Application Ref:	2026/0301			 Ribble Valley Borough Council www.ribblevalley.gov.uk
Date Inspected:	24/06/2026	Site Notice:	24/06/2026	
Officer:	EP			
DELEGATED ITEM FILE REPORT:				APPROVAL

Development Description:	Proposed erection of single-storey porch extension to side elevation, introduction of two new window openings in either side elevation at second floor level and new rooflight in principle roofslope.
Site Address/Location:	Well House Main Street Grindleton Clitheroe BB7 4QT.

Drawing Name: Proposed Floor Plans

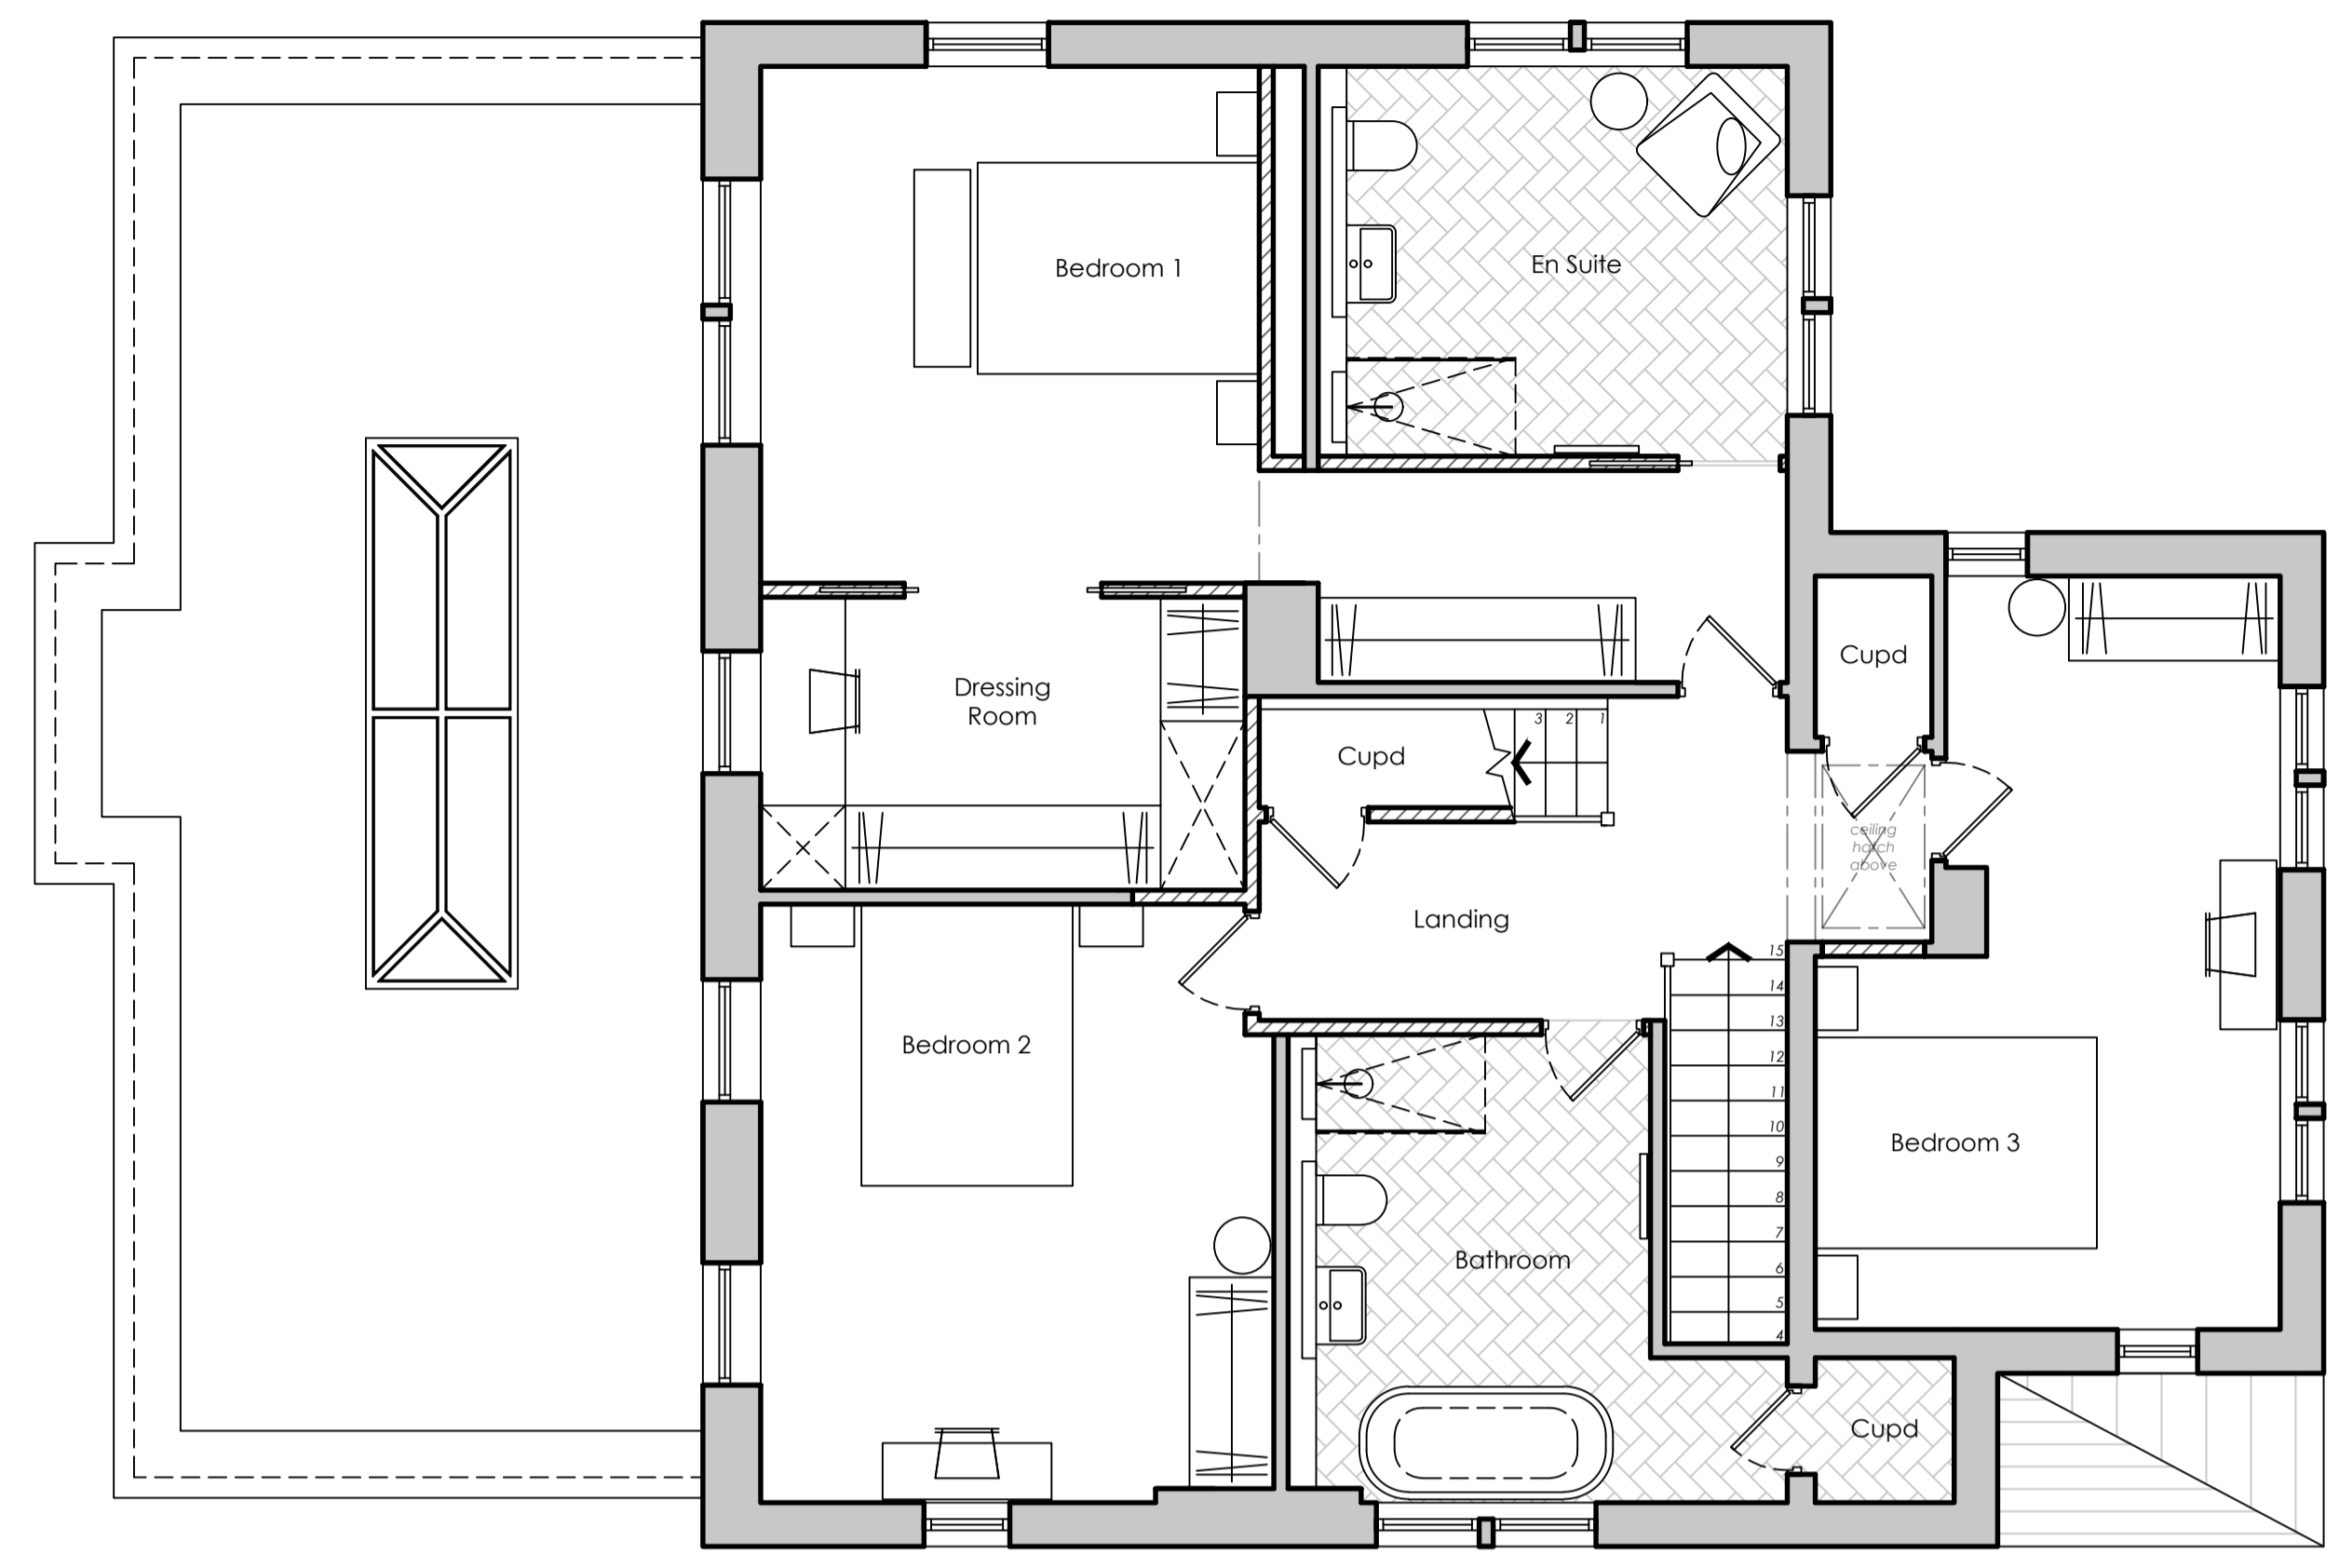
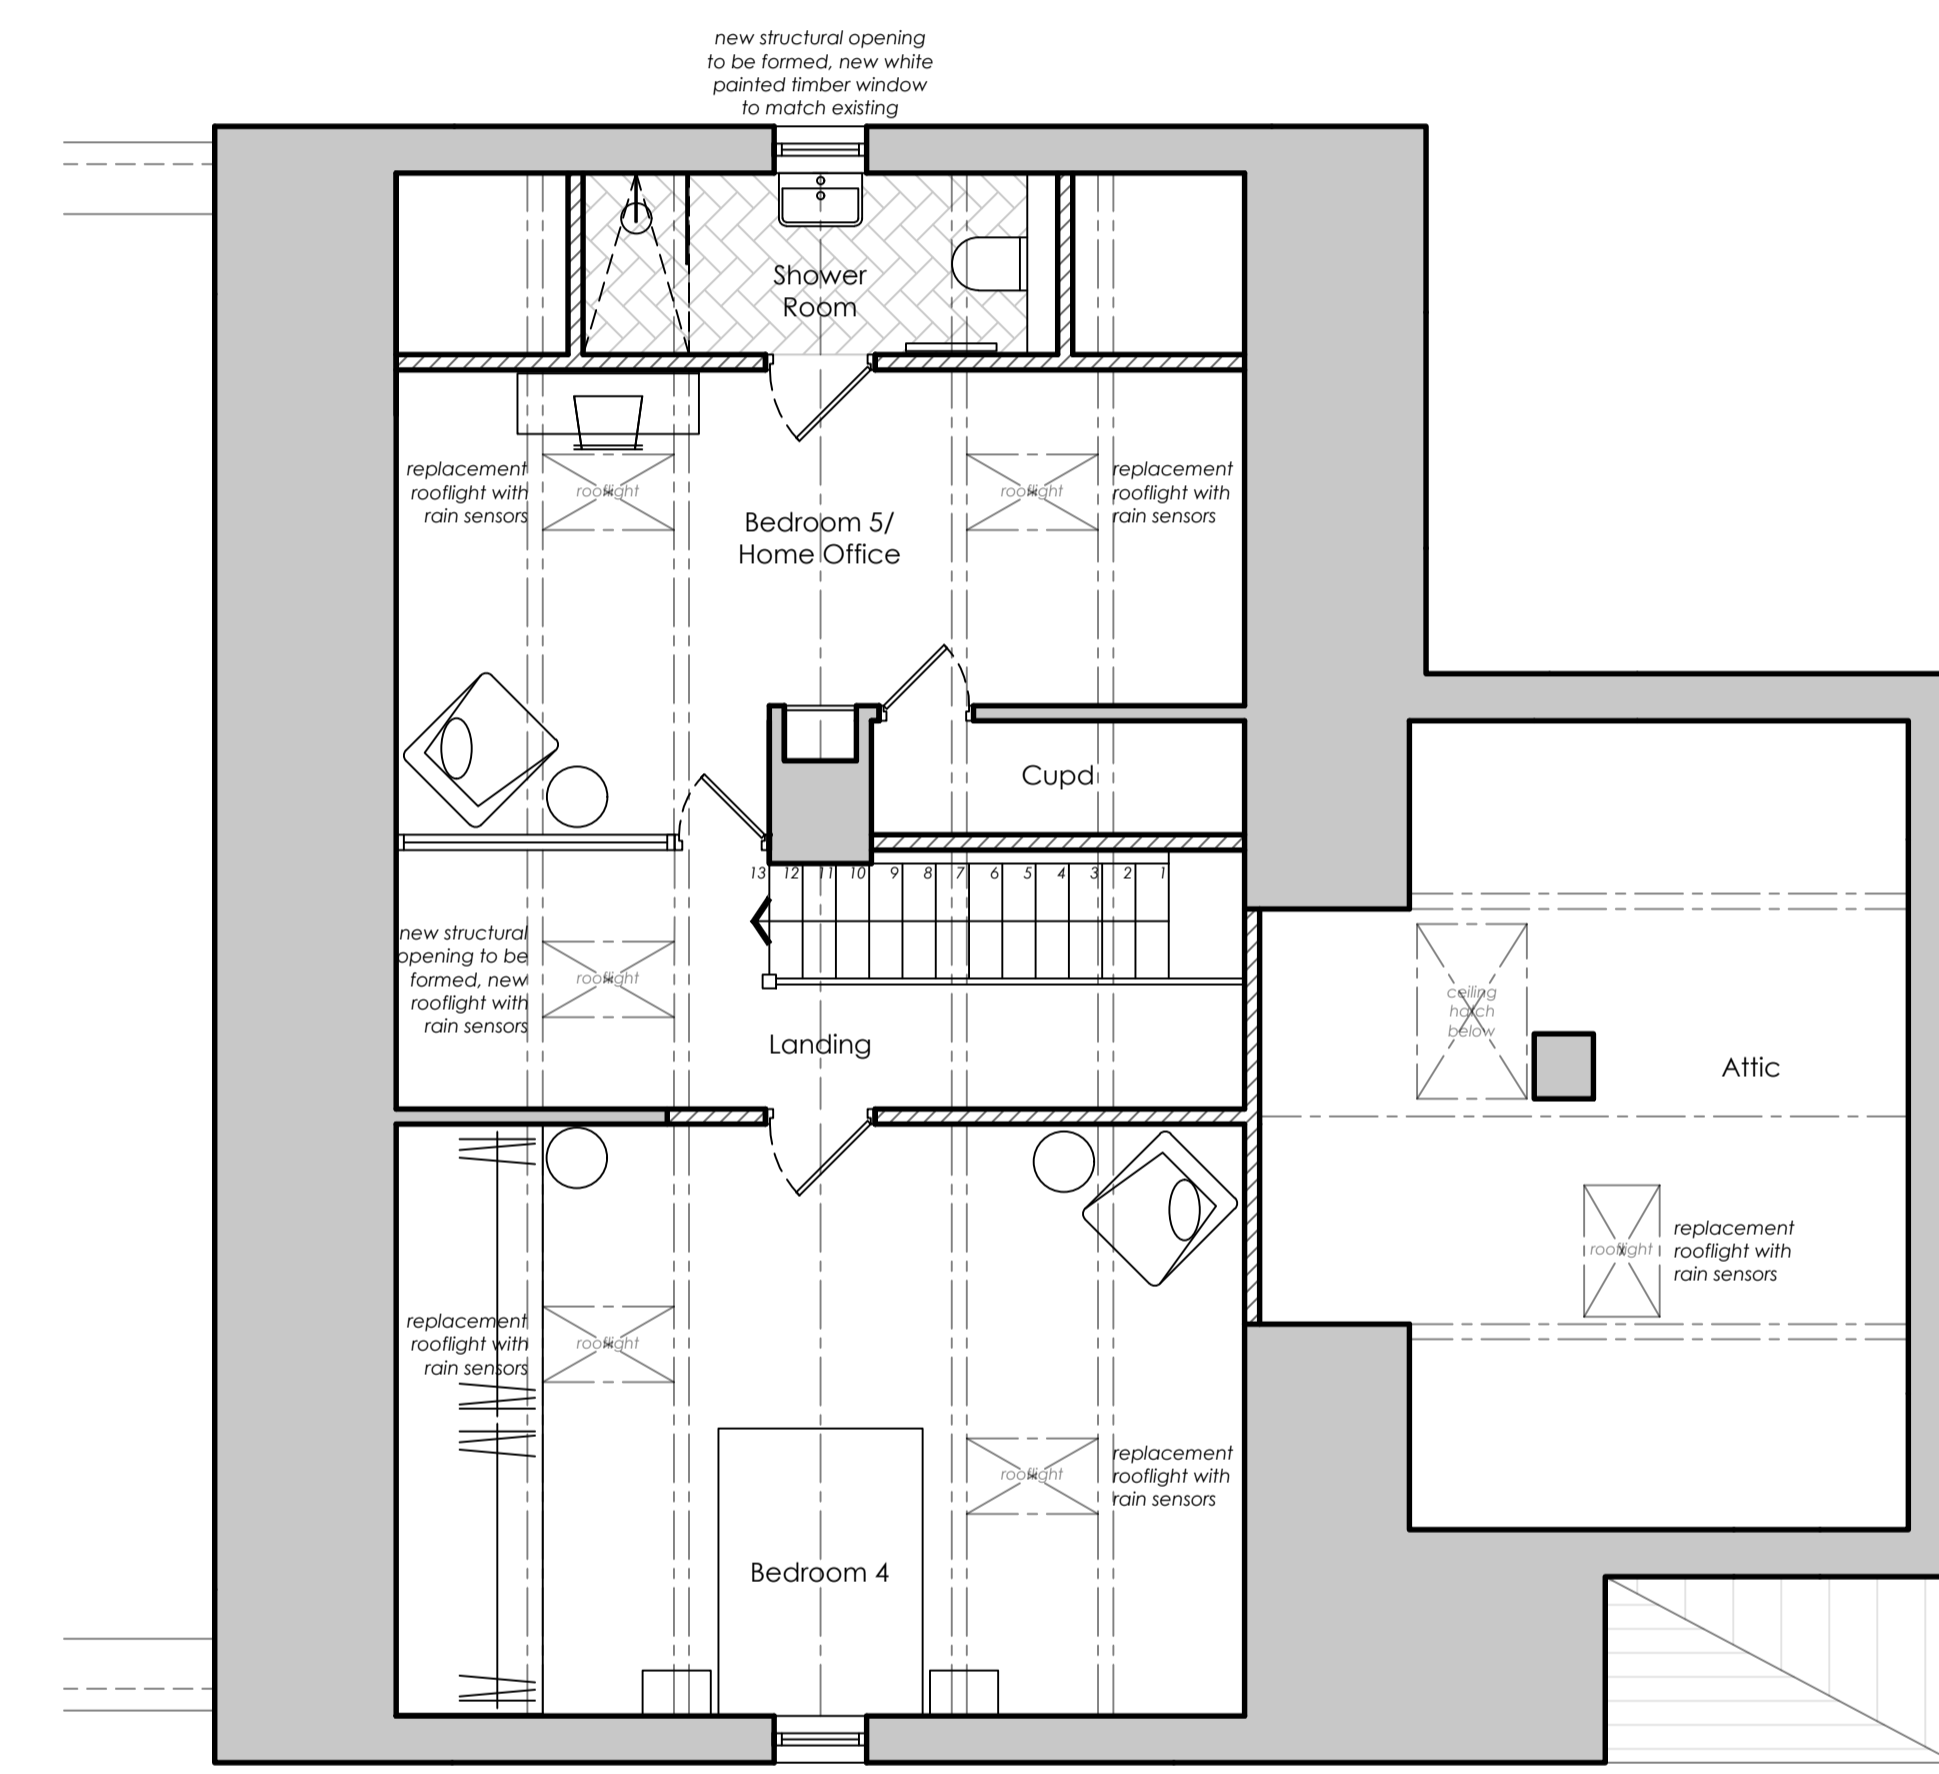
The proposed second floor windows are located within the side elevations of the dwelling and therefore limited views of these would be afforded from within the street scene. Nonetheless, these will be timber framed to match the dwelling and will integrate sufficiently into the street scene.

There are two new window openings proposed at second floor level. The application dwelling is set back from the linear form of the road and as such is set behind its neighbouring dwellings. As a result, the proposed new windows do not create opportunity for direct overlooking. There may be a slight perception of overlooking created for the receptor to the south. This can be mitigated through obscure glazing, which can be secured via planning condition.
